Riverview House, Uxbridge

Class 0 Change of Use Application

Project Title:	Riverview House, Uxbridge
Project Ref:	1153
Report Title:	Class 0 Change of Use Application
Report Ref:	P931
Revision:	0
Date of Issue:	September 2022
Purpose of Issue:	Information
Compiled By:	Beatriz Antuna Tentor
Reviewed By:	Ben Paterson
Review Date:	12-09-22
File Location:	-

TPM Studio have been asked on behalf of Permitted Developments Investments No. 7 Ltd to prepare and submit a statement in support of the Section 73 Application relating to the proposed redevelopment of Riverview House in Uxbridge.

Project Title: RIVERVIEW HOUSE, UXBRIDGE
Project Ref: 1153
Status: PLANNING
Scale: 1:100 / A1
Sheet Title: GA PROPOSED GROUND FLOOR PLAN
Sheet Ref: P130 / 0

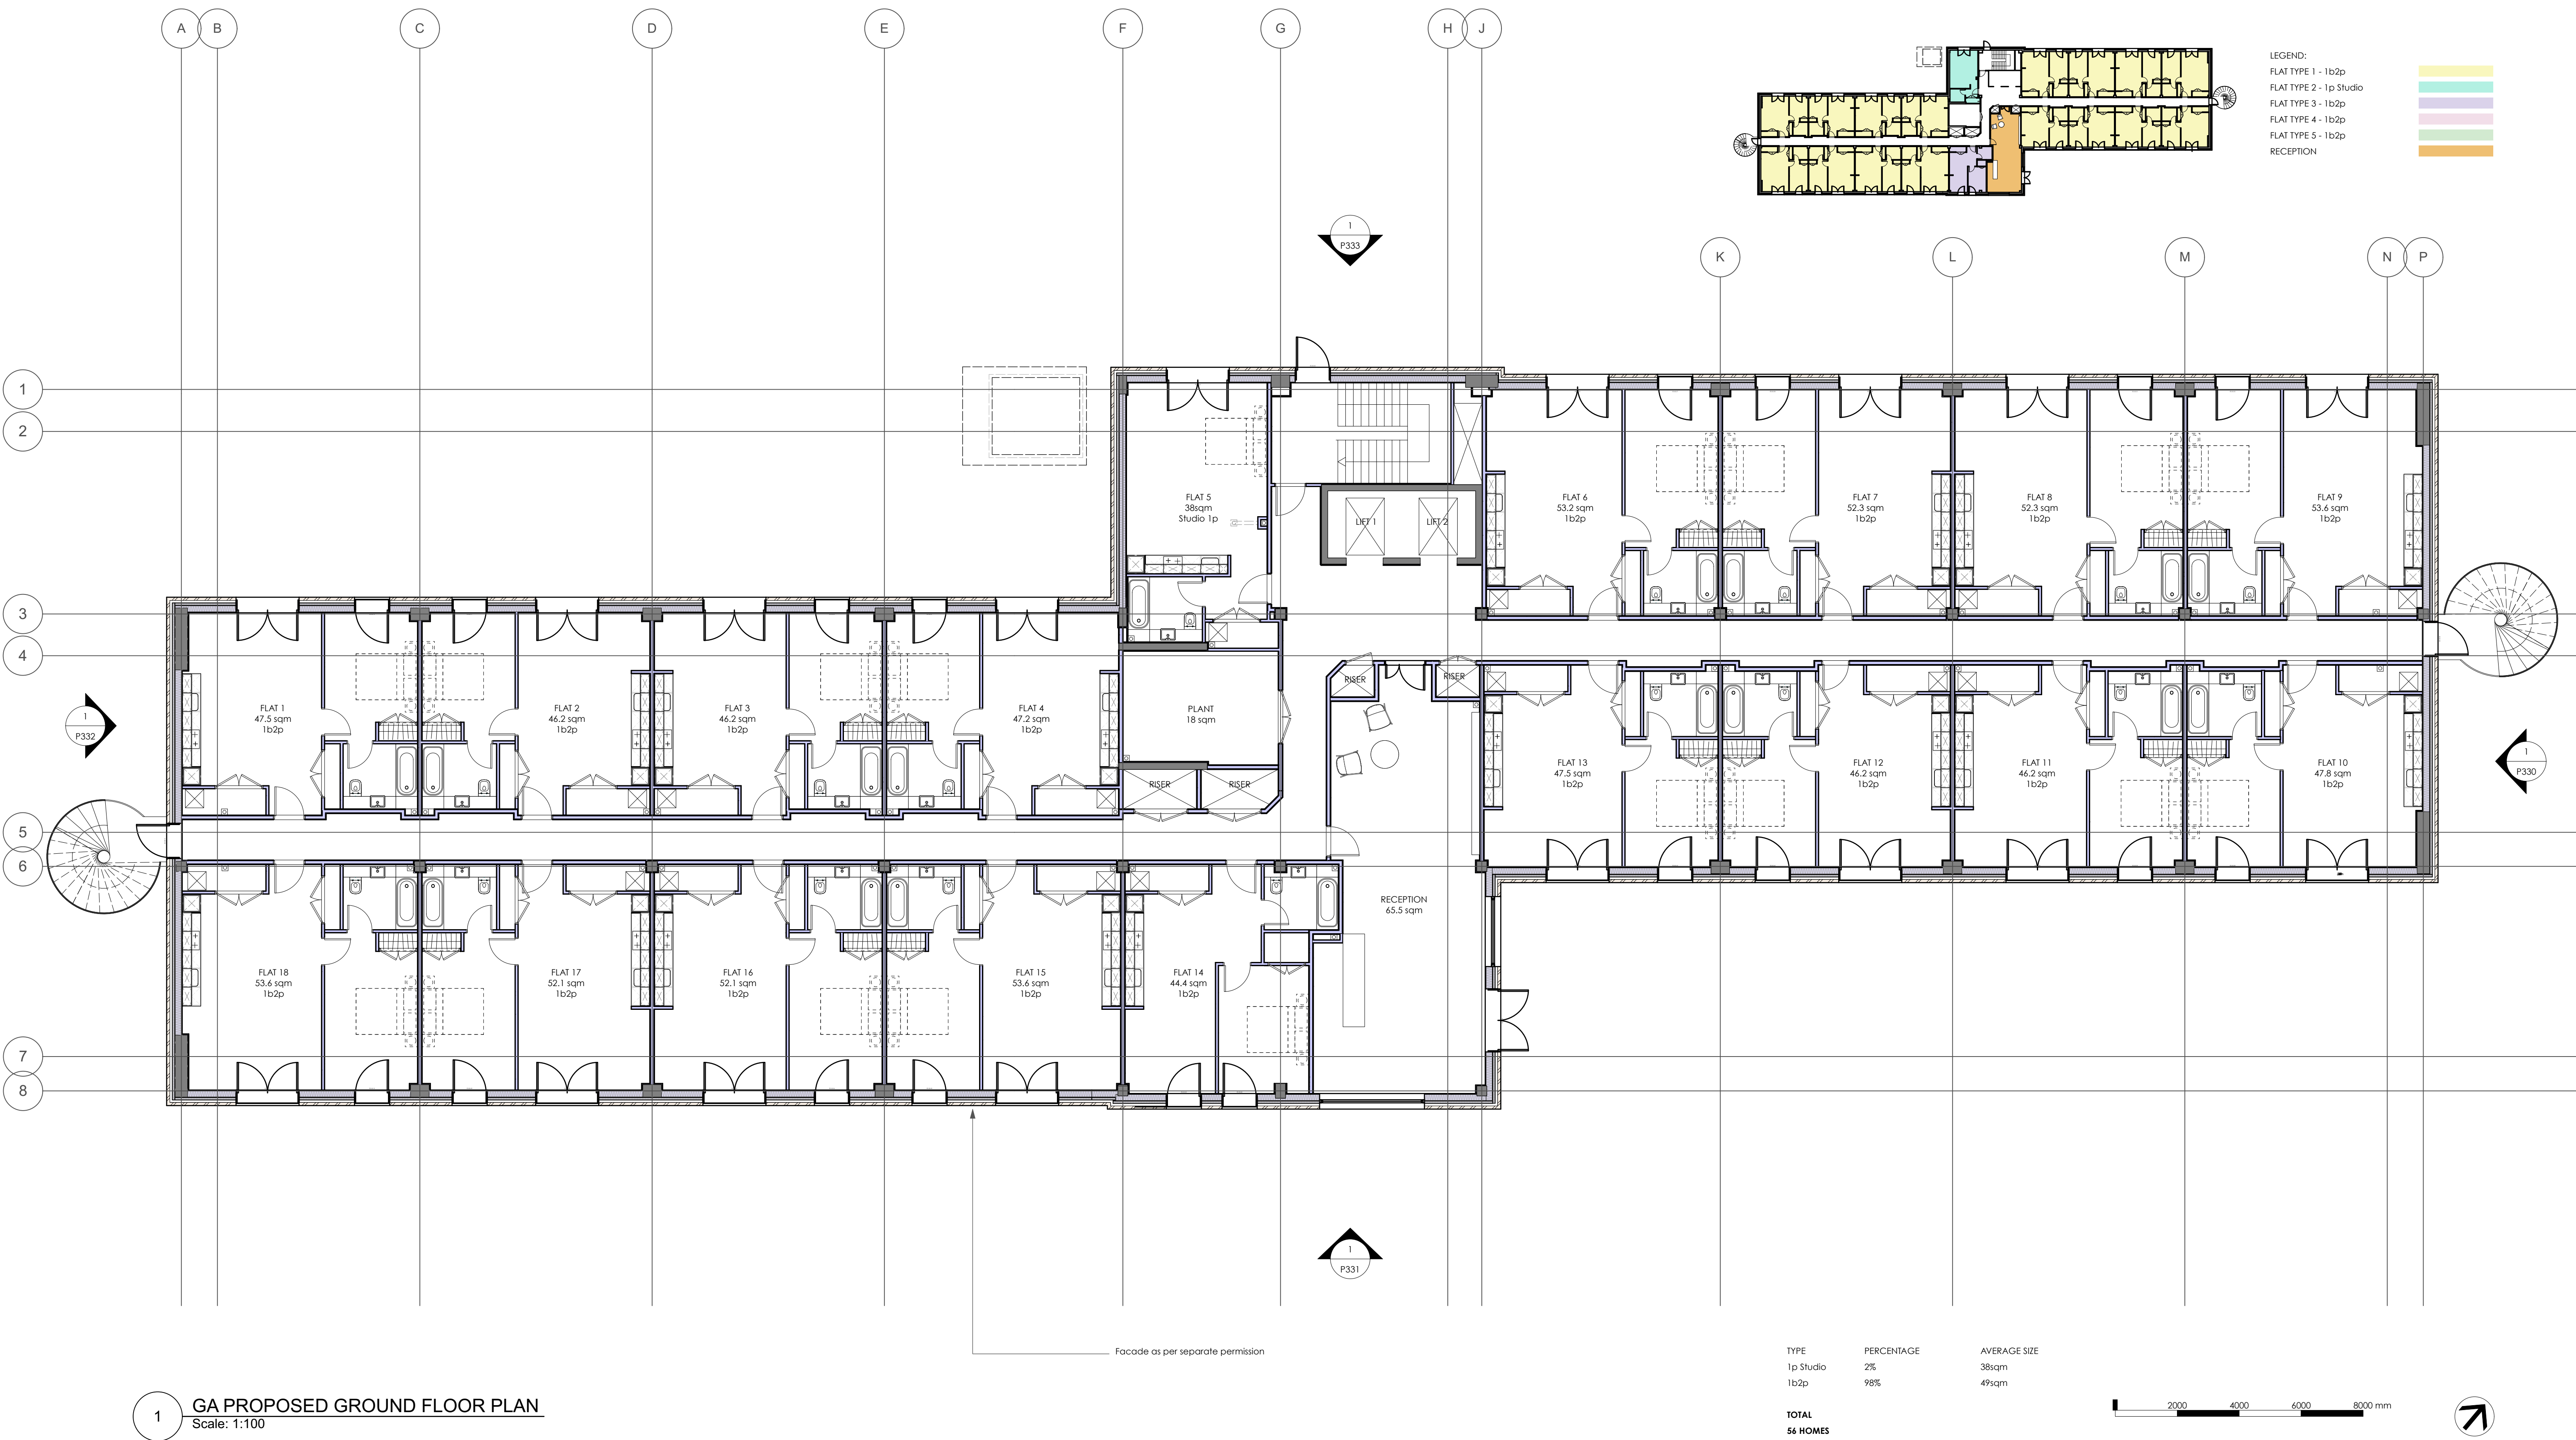
- The arrangement of apartments on the ground, floors, is consistent with the consented scheme where the predominant changes occur along the internal wall of apartments where the width of the corridor has narrowed slightly to allow for generally 1200mm clear wall-to-wall, with passing spaces 1500mm in width. The naming conventions of the individual apartments is consistent with the NDSS and the previous application.

- Minor rationalisation of the ground floor reception and 1b2p apartment adjacent where the size and location of the existing structure is now better understood following strip out of the existing building.

- Minor internal modifications of apartments to create improved, more open plan living accommodation, with better access to storage.
- Rationalised arrangement of bathrooms and coordination of services between the ground and fourth floors.

- Modification of Apartment 5 (left-hand side of the stair core) owing to the position of the existing primary structural fin walls which cannot be removed.

- To the north and east elevations, where windows were previously not identified on plan these are now captured.
- Revised riser positions and sizes following MEP advice.

Project Title: RIVERVIEW HOUSE, UXBRIDGE
Project Ref: 1153
Status: PLANNING
Scale: 1:100 / A1
Sheet Title: GA PROPOSED FIRST FLOOR PLAN
Sheet Ref: P131 / 0

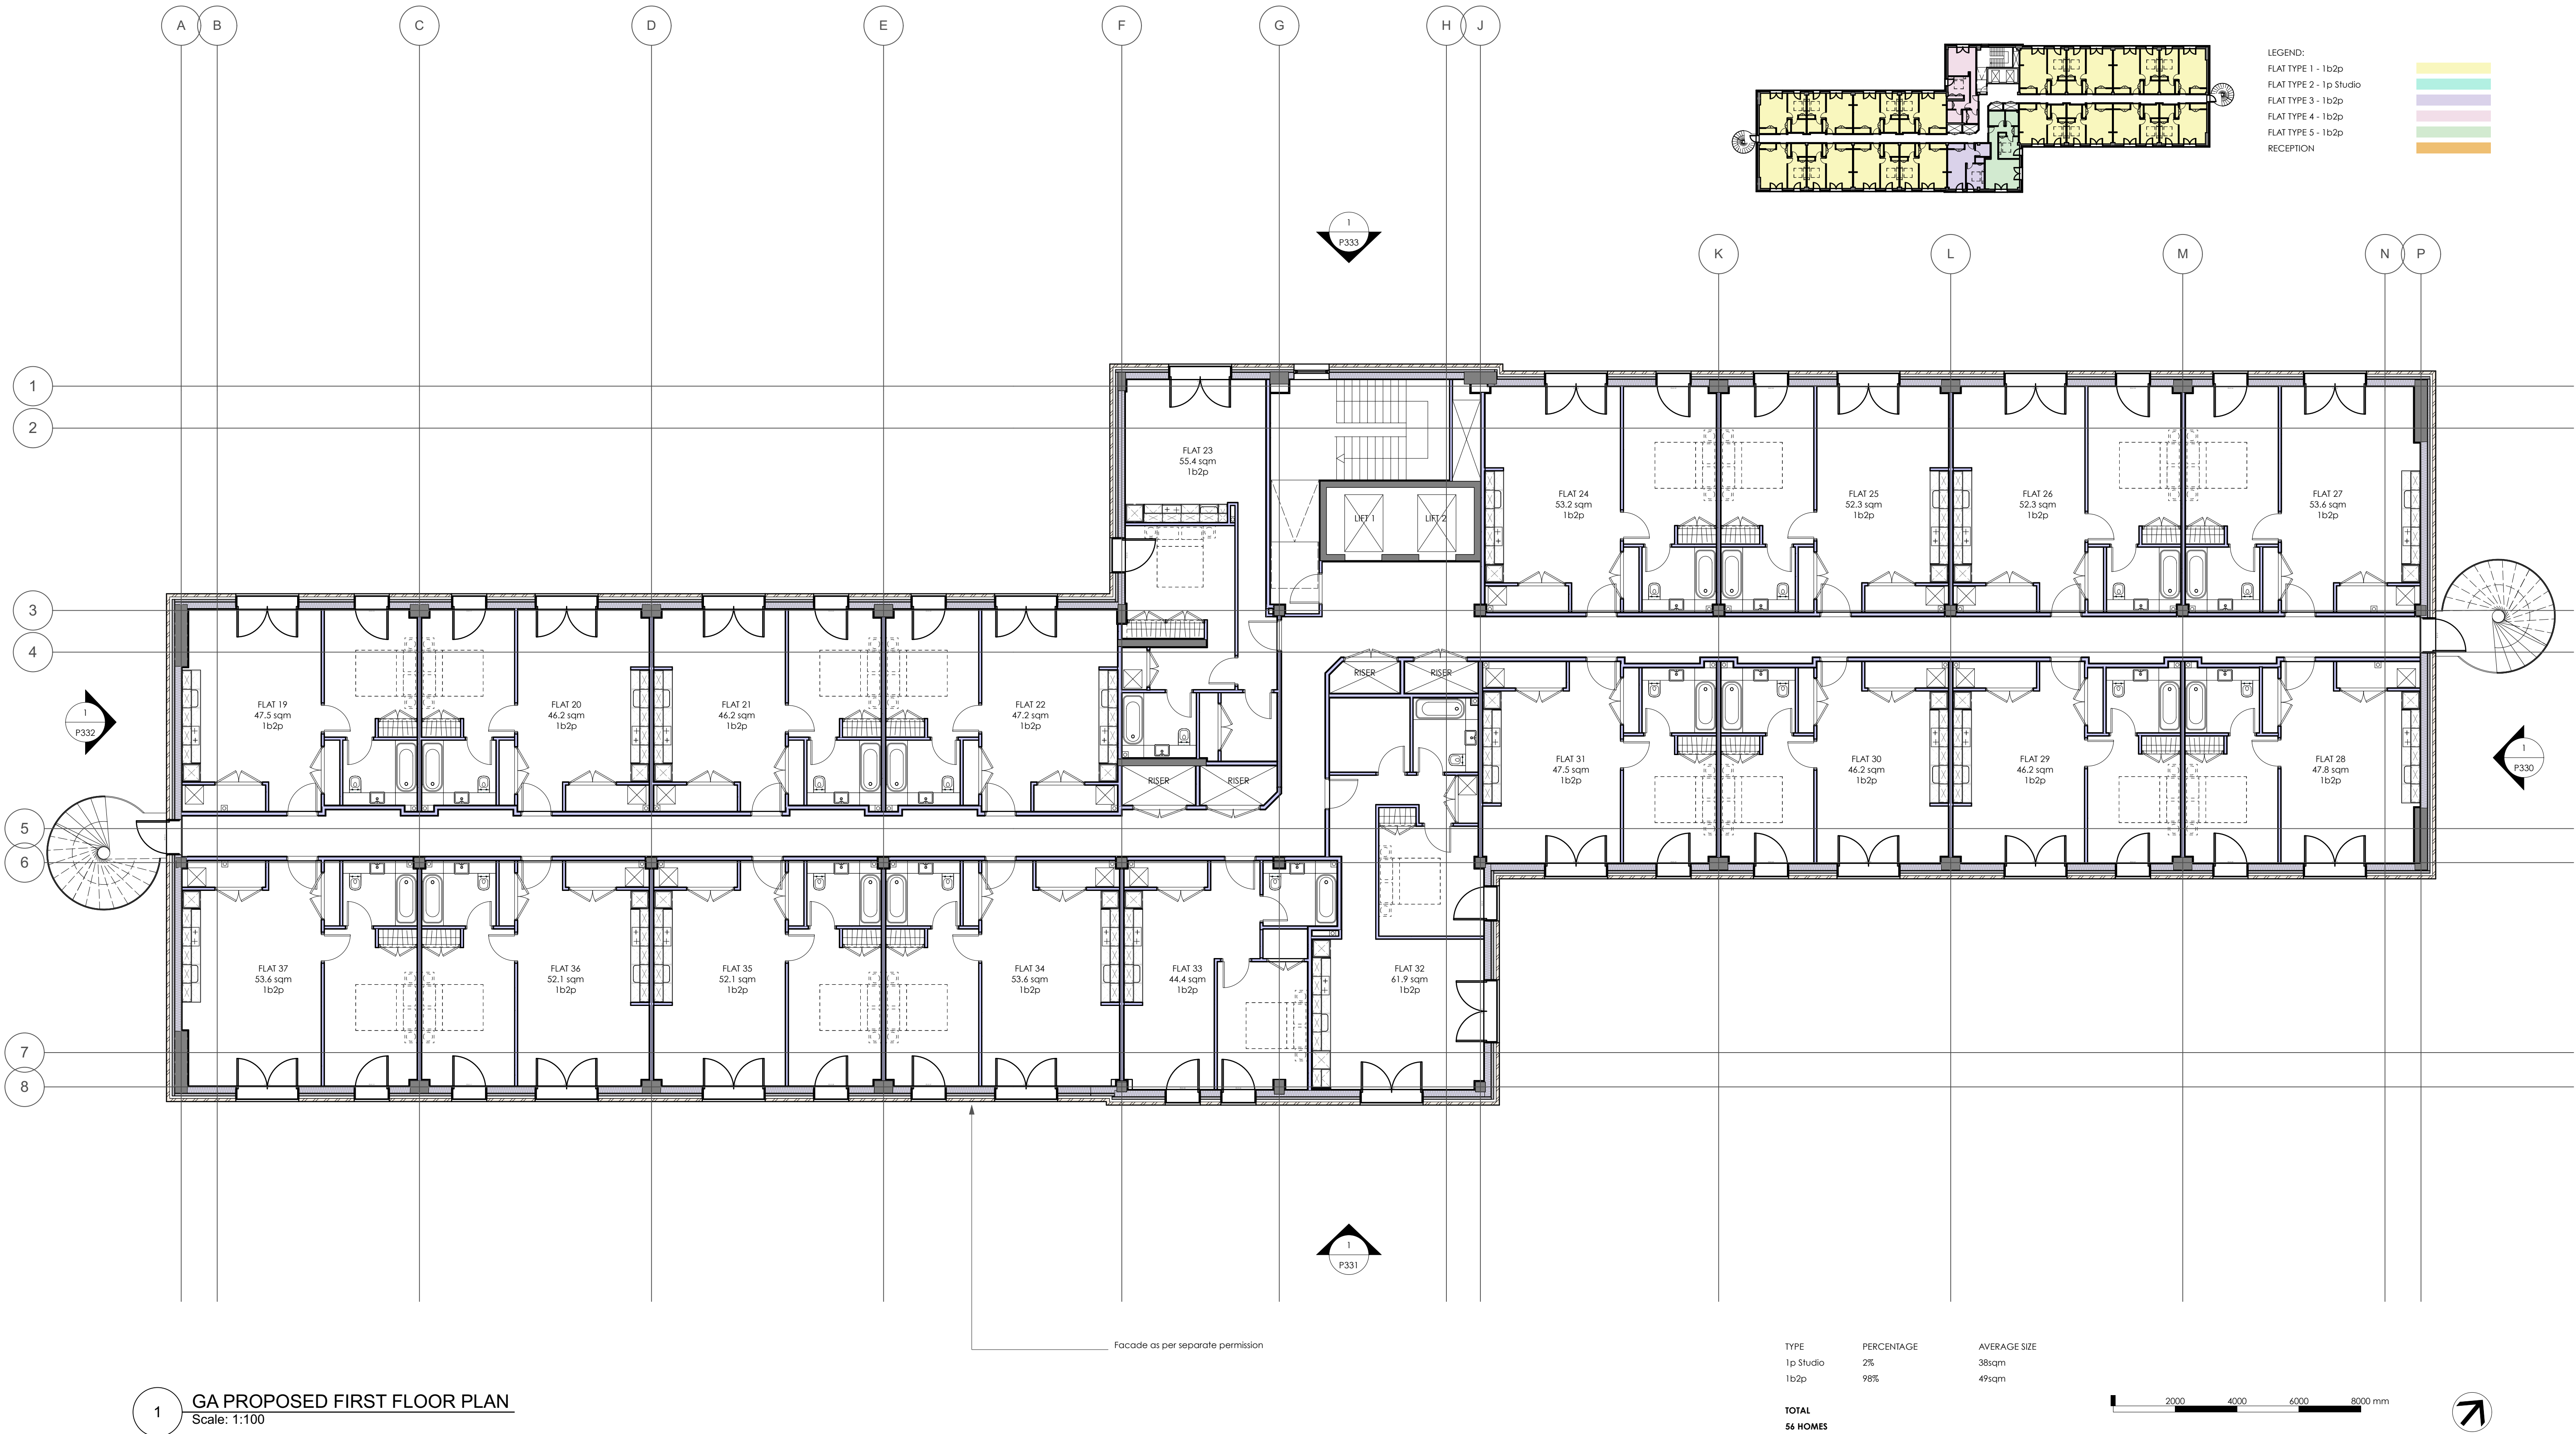
- The arrangement of apartments on the first and second floors are consistent with the consented scheme where the predominant changes occur along the internal wall of apartments where the width of the corridor has narrowed slightly to allow for generally 1200mm clear wall-to-wall, with passing spaces 1500mm in width. The naming conventions of the individual apartments is consistent with the NDSS and the previous application.

- Inclusion of a localised ramp adjacent to the lift core and between the stair landing and the lift lobby. The ramp allows for level differences between the slab and stair landing.

- Minor internal modifications of apartments to create improved, more open plan living accommodation, with better access to storage.
- Rationalised arrangement of bathrooms and coordination of services between the ground and fourth floors.

- Modification of Apartment 23/42 (left-hand side of the stair core) owing to the position of the existing primary structural fin walls which cannot be removed.

- To the north and east elevations, where windows where previously not identified on plan these are now captured.
- Inclusion of risers where these were previously missed of the arrangement plan.

- Modification of the internal layout of apartment 32/51, following changes to the arrangement of the service risers.
